**Consultation Response from KC,
Highways Development Management****2023/90958 adj, Hill Side, Cold Hill Lane, New Mill, Holmfirth, HD9 7JX****Erection detached dwelling****Date Responded: 8-8-2023.****Responding Officer: Mark Berry****Responding Ref: 12-15-12.**

This application seeks approval to the erection of a 4 bedroomed detached dwelling with double integral garage at land adjacent to Hill Side, Cold Hill Lane, New Mill, Holmfirth.

Site Plan
1:200

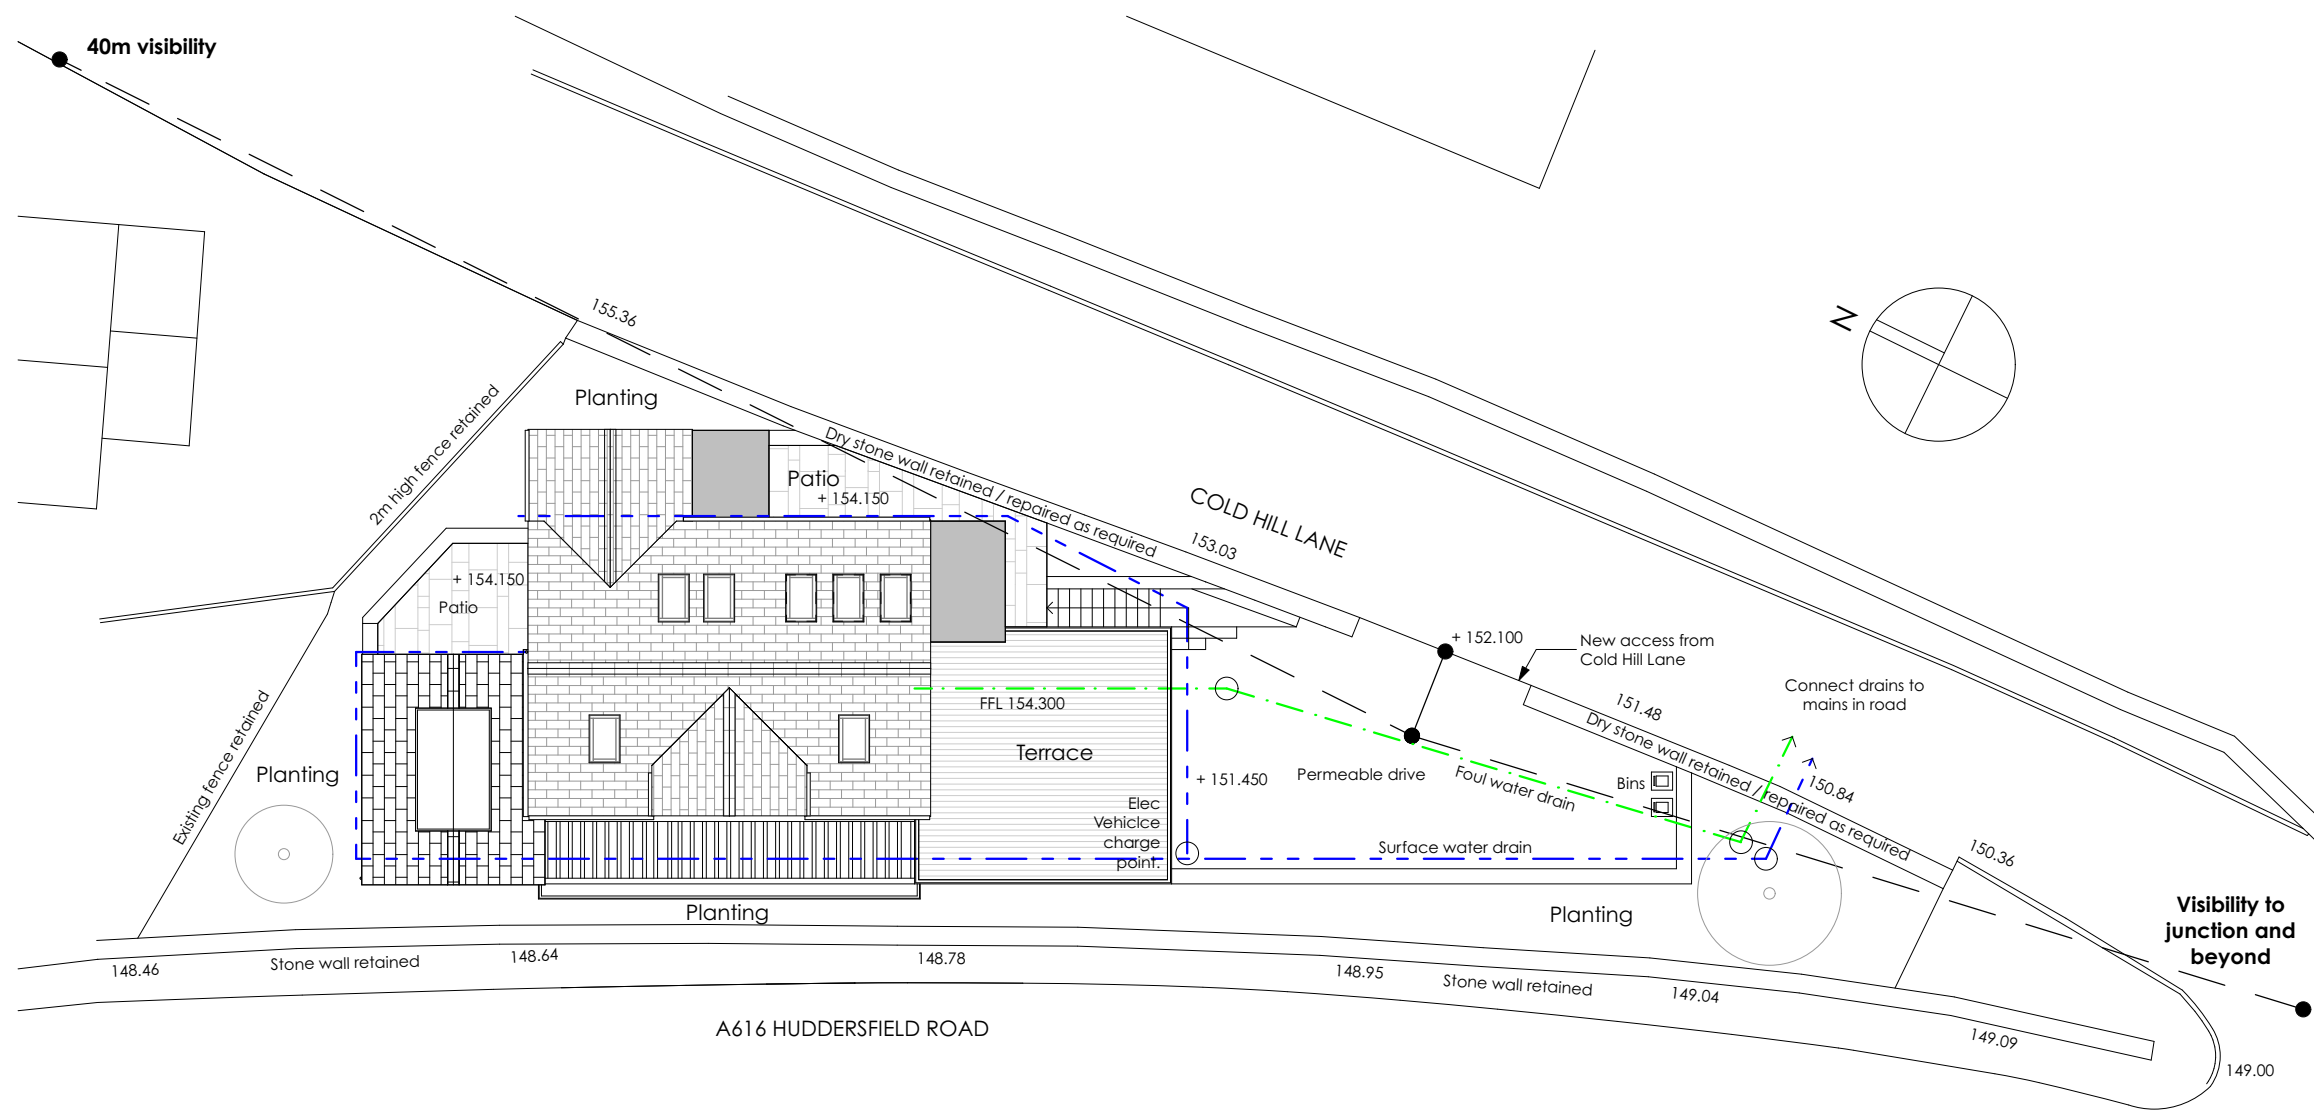
As with the previous approval access to the proposed dwelling is directly from Cold Hill Lane at approximately the same location of plot 2 of the previous permission. Sight lines are shown from this access to the junction with Huddersfield Road to the south and to 40 m to the north.

The applicants should be asked to demonstrate that the proposed sight lines are achievable.

The Sight lines are shown over the adjacent steps, boundary walls and the canopy through the slatted timber screen to the front door. The driveway in front of the garage is at a level of 151.45m with Cold Hill Lane at a level of 153.03m above plus there is a boundary wall at this location.

Swept paths should also be provided to demonstrate that a vehicle can enter and exit the proposed driveway in a forward gear.
